SECOND FLOOR PLAN

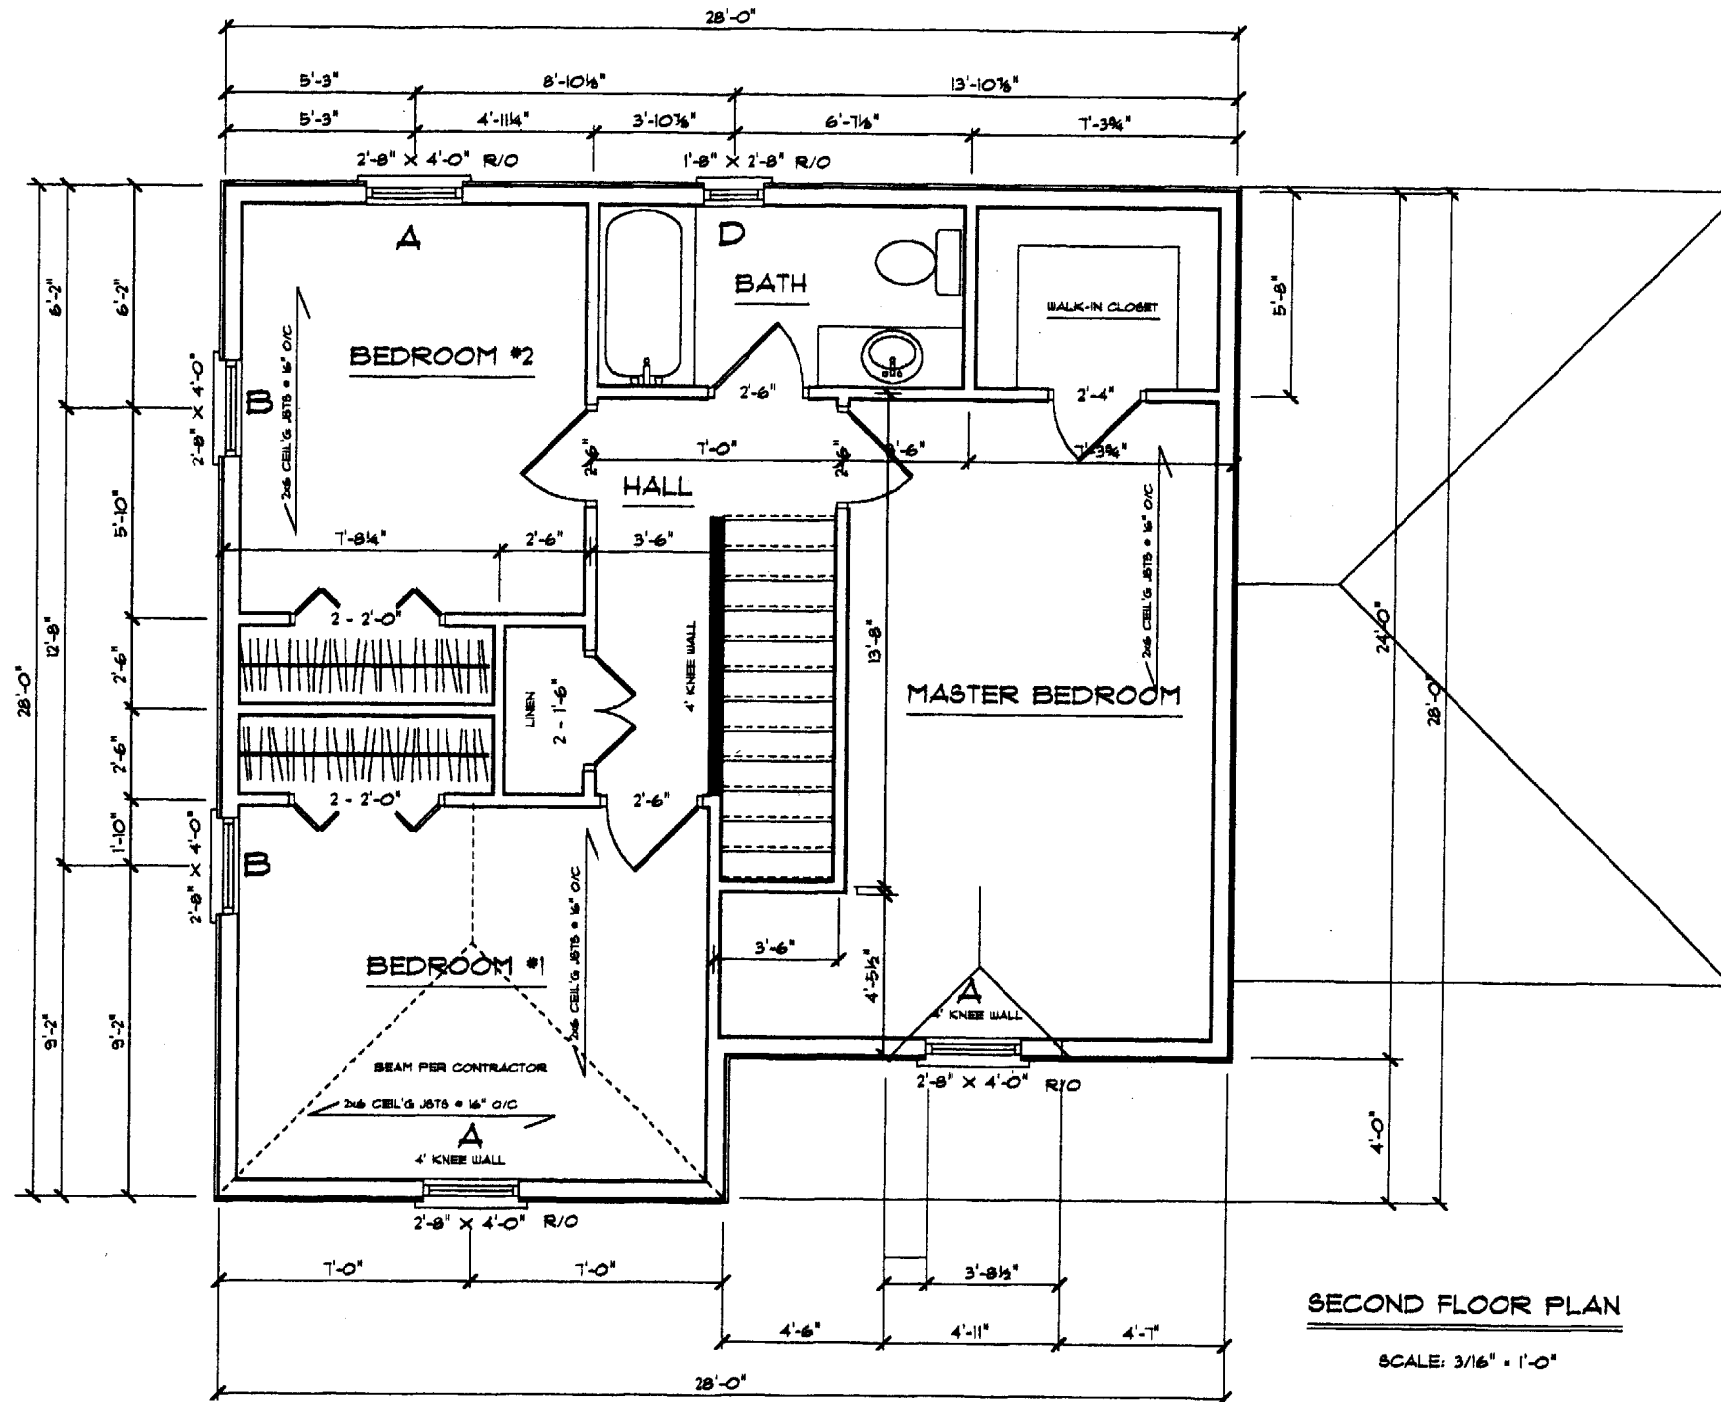
BATH window second Floor needs to be safety glazed ok
within 3' of walking surface of slab. Egress windows

need adjustment to $24\frac{1}{2}$ to meet S.7. width $33\frac{5}{8}$. ok

FOUNDATION PLAN
 Allen Ave Lot 4
 11'-0"

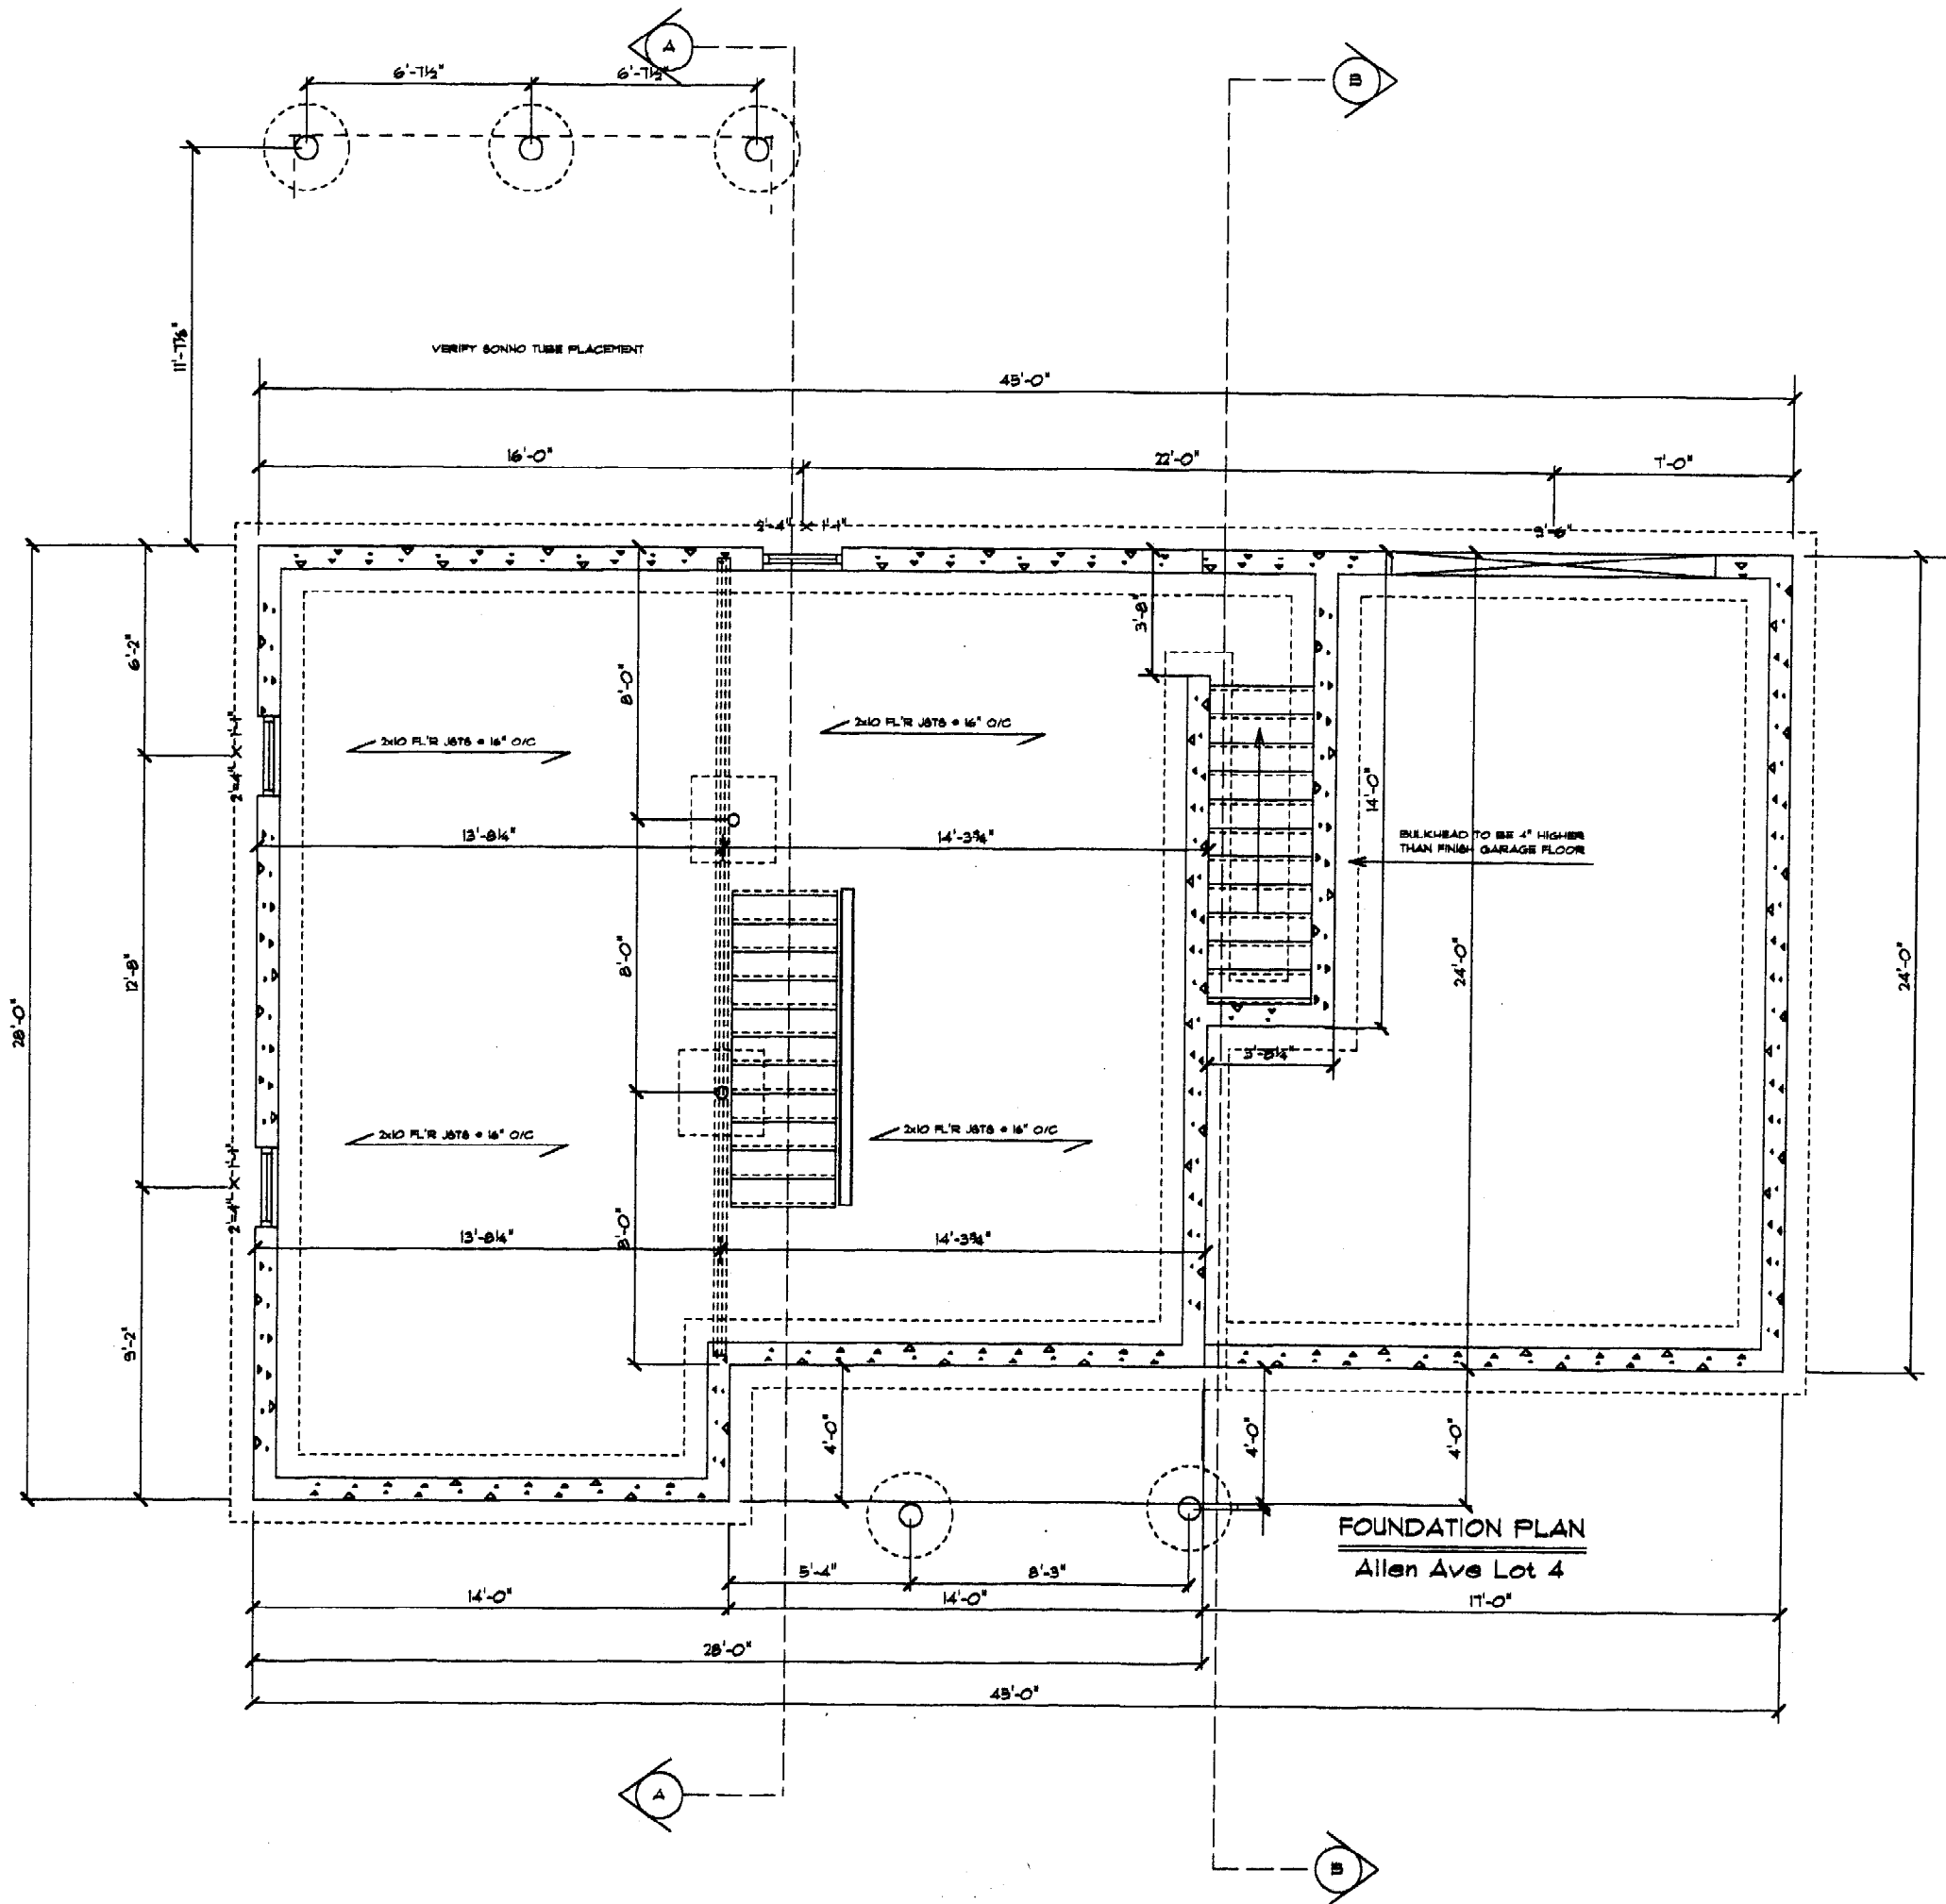
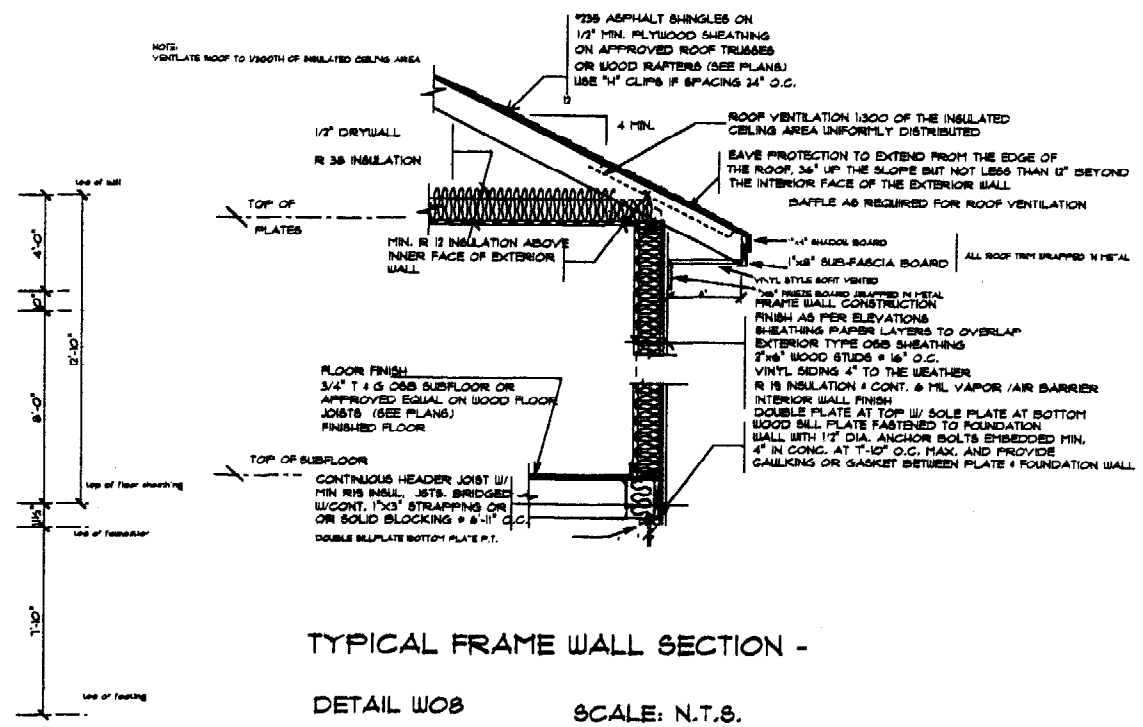
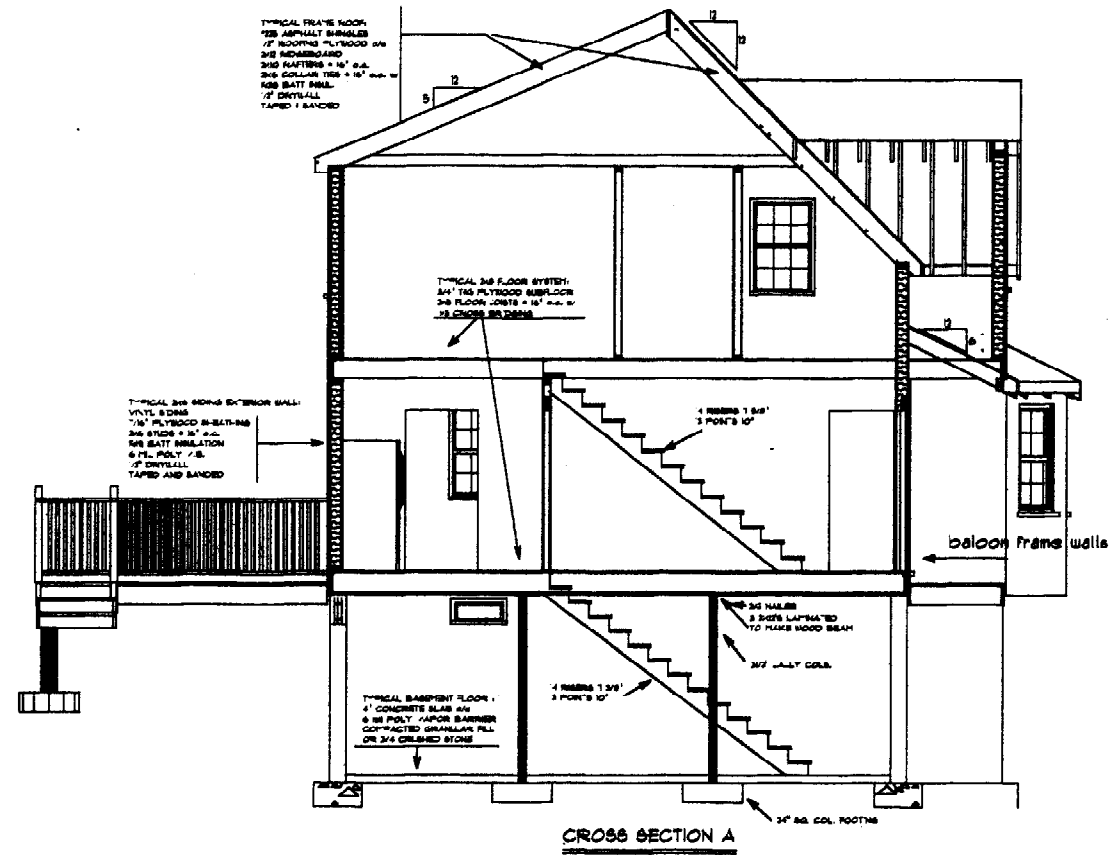
Joist Hangers needed in basement right side where bearing ok
is less than $1\frac{1}{2}$ " on wall. OK to Close in JB
Decks not complete - stairs ok.
